## Subdivision Comments

From: Jesse Cox, Environmental Health Supervisor  
Holly Erdman, Environmental Health Specialist

RE: SP-20-00003

KITITAS COUNTY	DATE	JOB NO.
DWN BY T.R./G.W.	10/2020	07102
CHKD BY D.N./D.L.P.	SCALE 1" = 100'	SHEET 1 OF 2

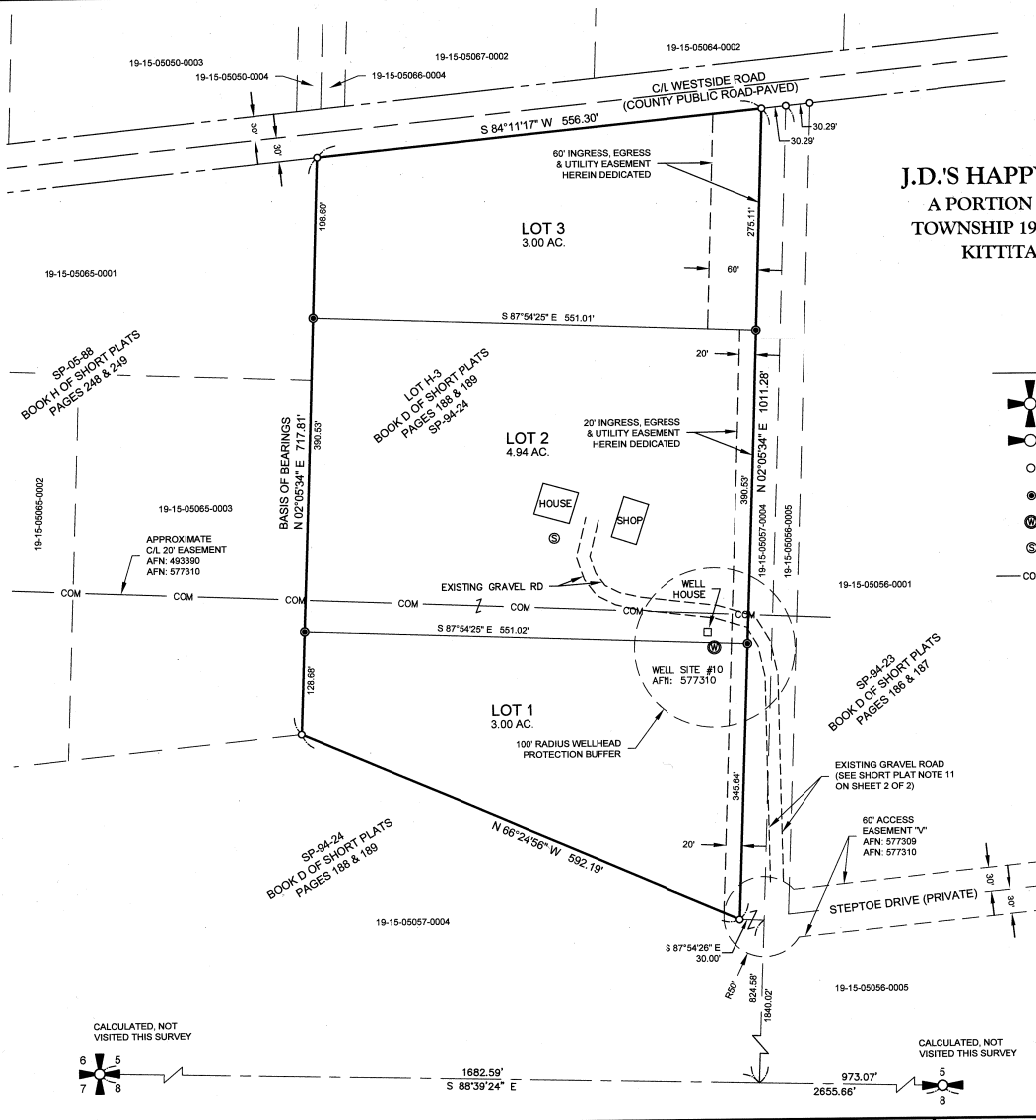
**B-1** 13.35.020(b) requires proof of adequate water supply, which can be submitted through a well log or 4 hour draw test result. If shared wells are used, a signed, notarized, and recorded shared well-users agreement must be submitted. All individual and shared wells must meet the distance requirement of 50 feet from the property line, 50 feet from the septic tank and 100 feet from the drain field as per Kittitas County Critical Areas Ordinance 17A.08.25, and KCC Chapter 13. Locations of wells on lots 1 and 3 must be provided.
